From: Simon Davis
Sent: 15 March 2018 11:28
To: Planning Scanning
Subject: FW: AW/55/18/HH 3 The Orchard, Aldwick

Subject: AW/55/18/HH 3 The Orchard, Aldwick

PROPOSED ELEVATIONS

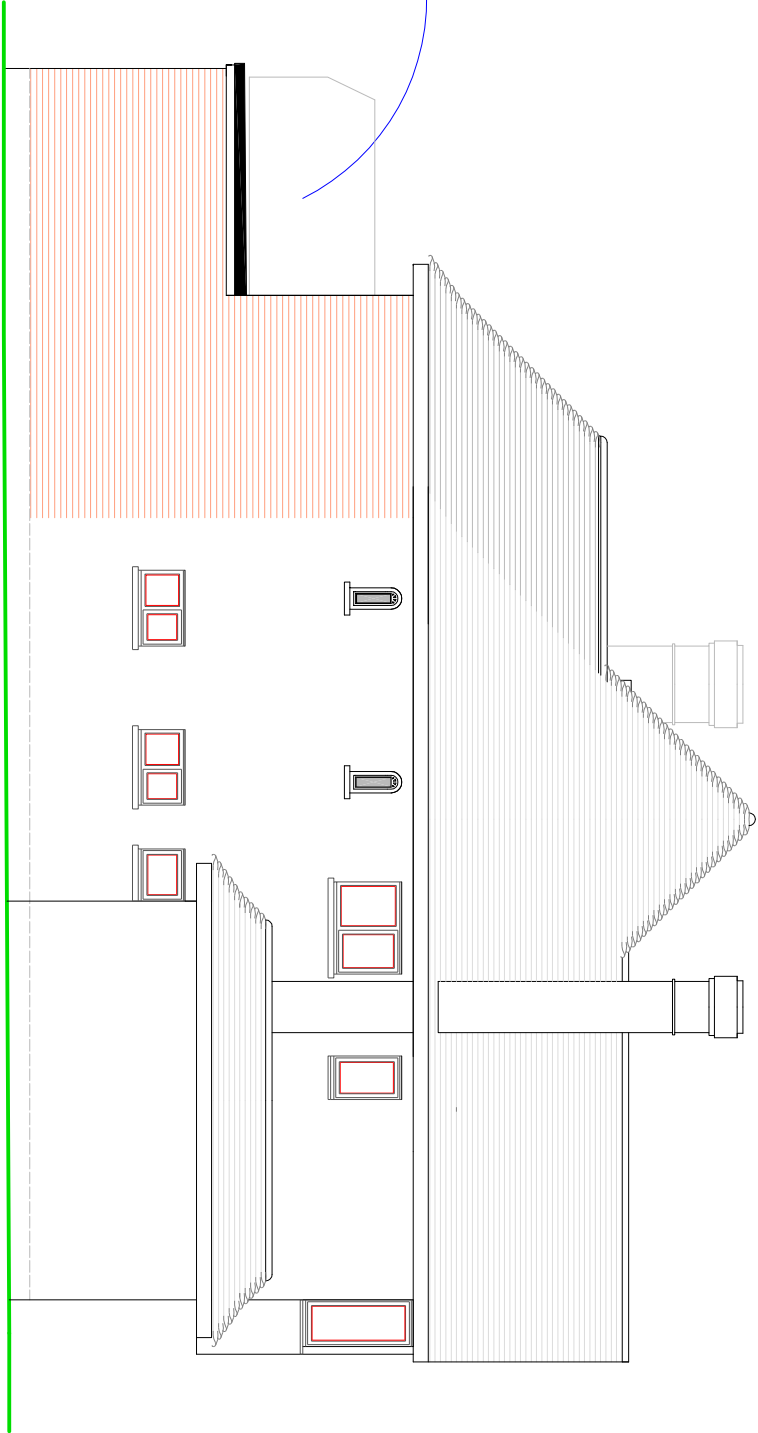
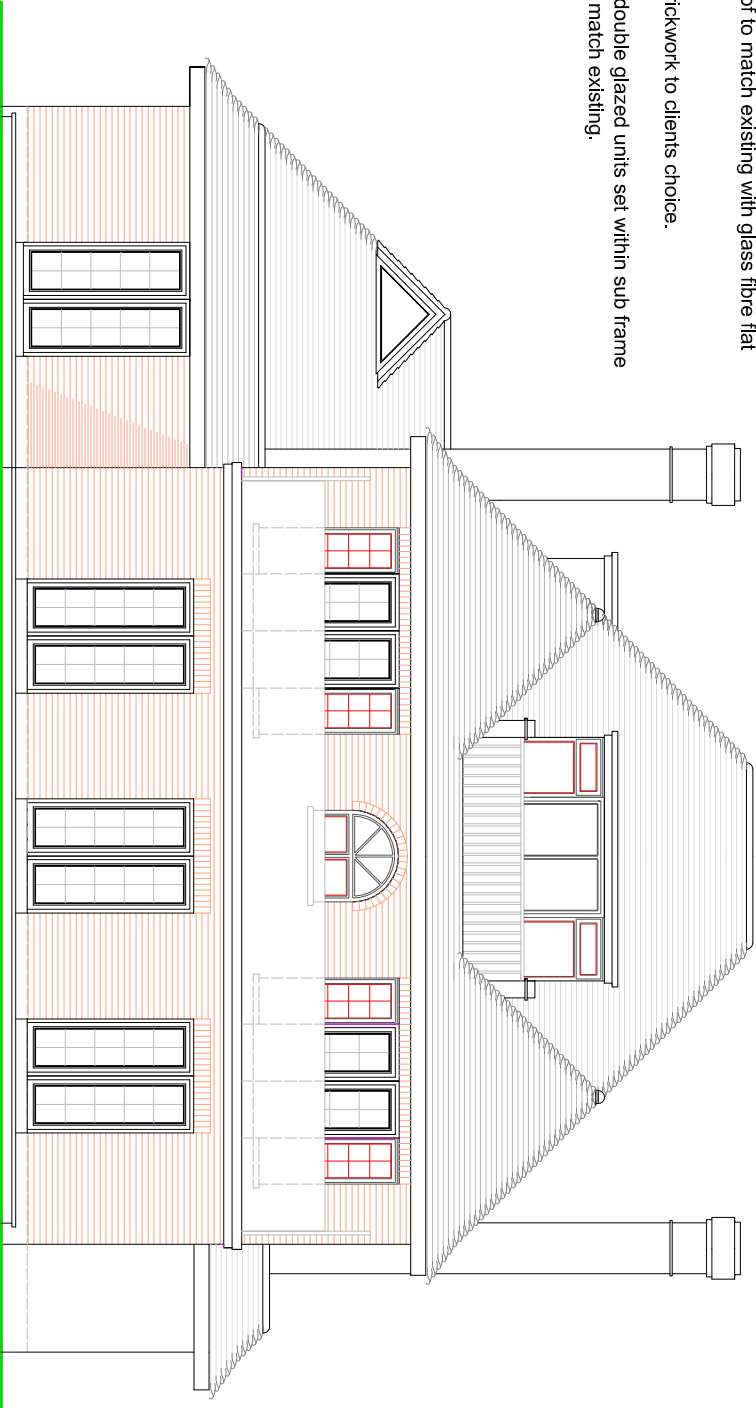
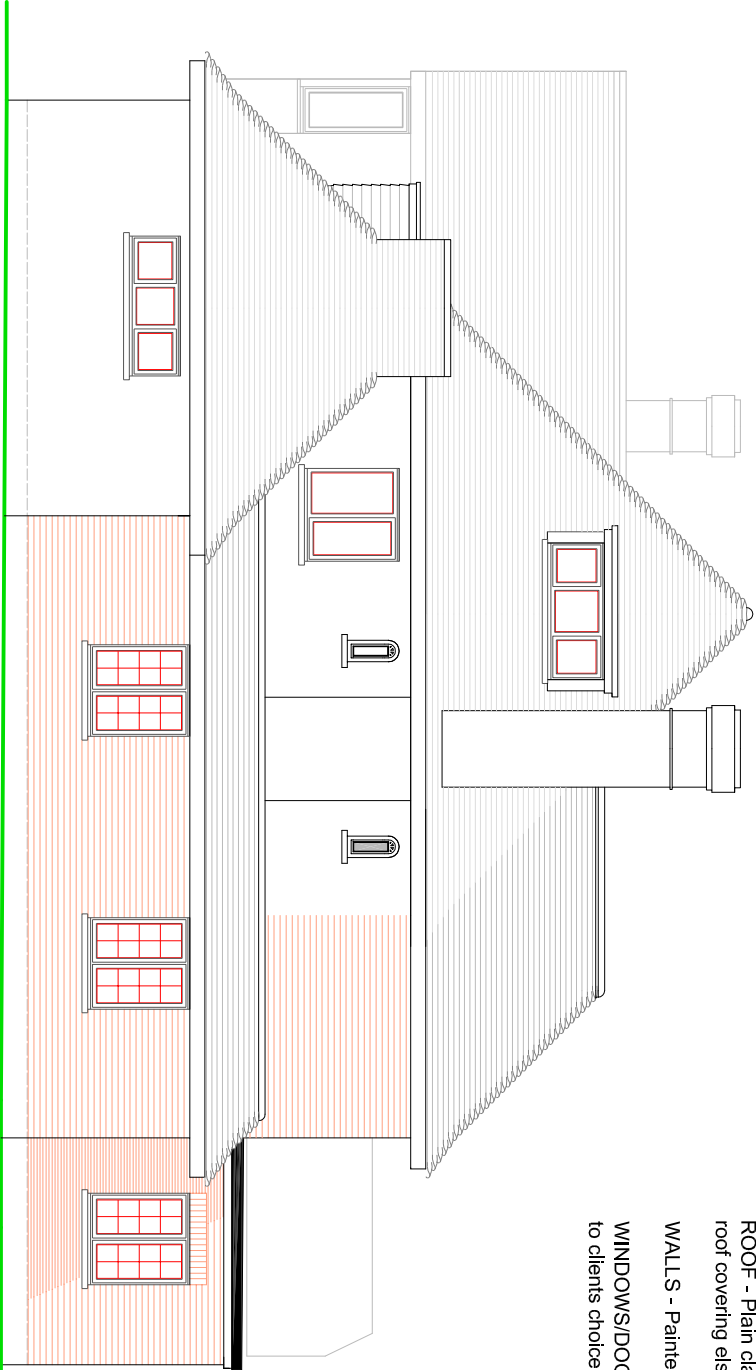
Clare has said that the balcony would be visible from the street, and glazing, although opaque, would be reflective. Metal (PCA or wrought Iron) would be considered acceptable alternative and a preferred choice (as per the previous comments).

We have had Conservation Officer comments which requests that the glazed balcony screen/barrier be changed to a non-reflective type surface. Could you make this change please.

Would you accept either a wrought iron effect balcony guarding on all three sides or if privacy to adjoining neighbours is sought, a brick side panel up to 1.7 metres high.
